Application No: M/72/20/DOC
Site Address: Land West of Yapton Road (Poultry Farm) Middleton-On-Sea PO22 6DY
Description of works: Approval of details reserved by condition imposed under ref M/45/16/PL relating to Condition Nos 11 - surface water drainage, 13 - discharge flows to watercourses and 14 - SuDs.

Thank you for your internet representation made on 12th October 2020 which has been recorded as an objection with the comments as follows:

I believe that the "Flood Risk Assessment and Drainage Analysis" document is severely flawed for the following reasons:

Figure 2
 Data logger data at borehole WS02

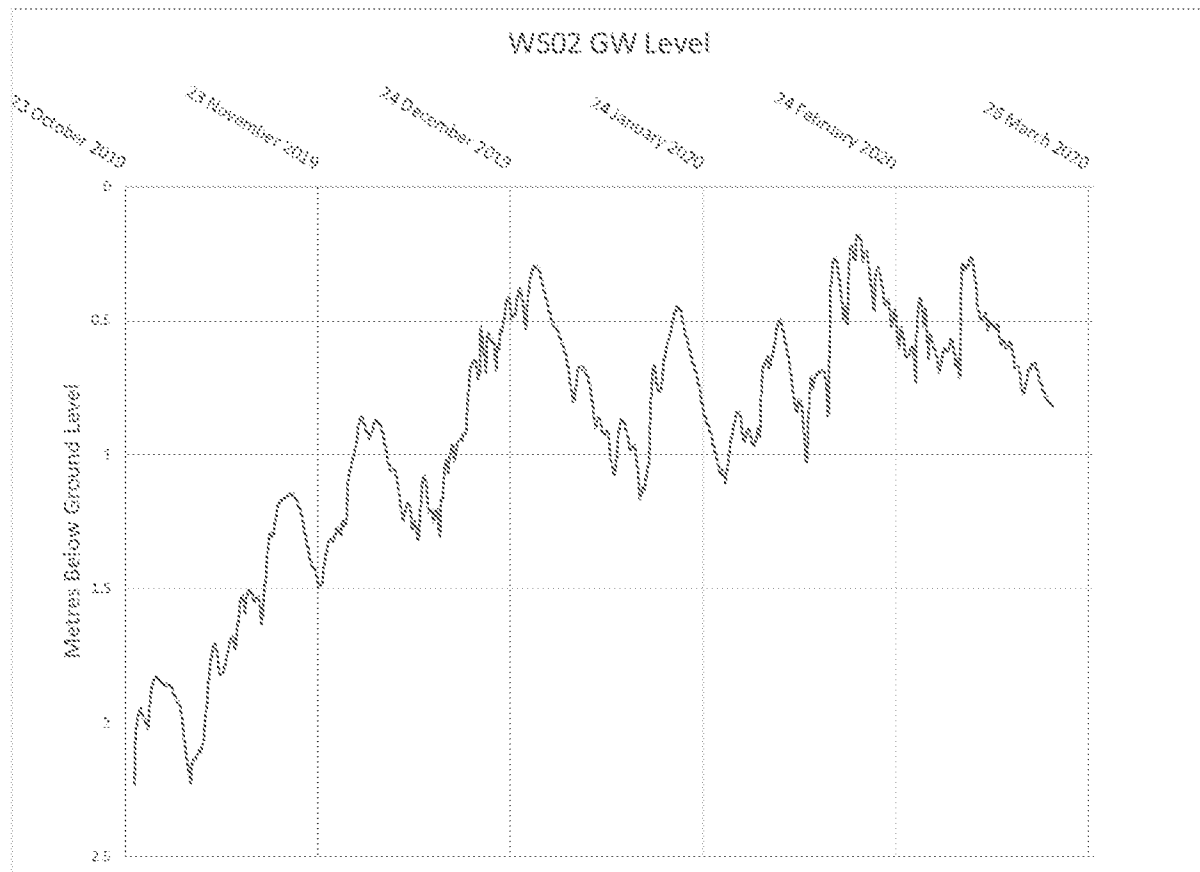
a. The water table analysis carried out between May 19 and March 20 was minimal and open to question. Only one data logger (at WS02) was used to provide continuous data; a point that, by admission within the report was not well placed to provide the most meaningful data for the care home site. The report claims that those at the more meaningful locations were "vandalised". A professional company should surely, over a ten-month period, have had ample opportunity to fix the issues! However, this did not happen, and instead they have extrapolated data obtained from the WS02 site, claiming that it is a fair representation of trends at the other sites from which they took just 4 dip readings across the period. However, as the Figure 2-1 shows there were clear discrepancies, and in March 2020 the readings at both of the other sites exceeded those at WS02 by a considerable margin. The WS01 figure is nearly a metre higher than that at WS02! However, the author of the report chooses to base their conclusions on WS02 data, quoting the highest figure from this point, rather than the others. Accordingly, the report is clearly nonsensical, and its validity should be questioned.
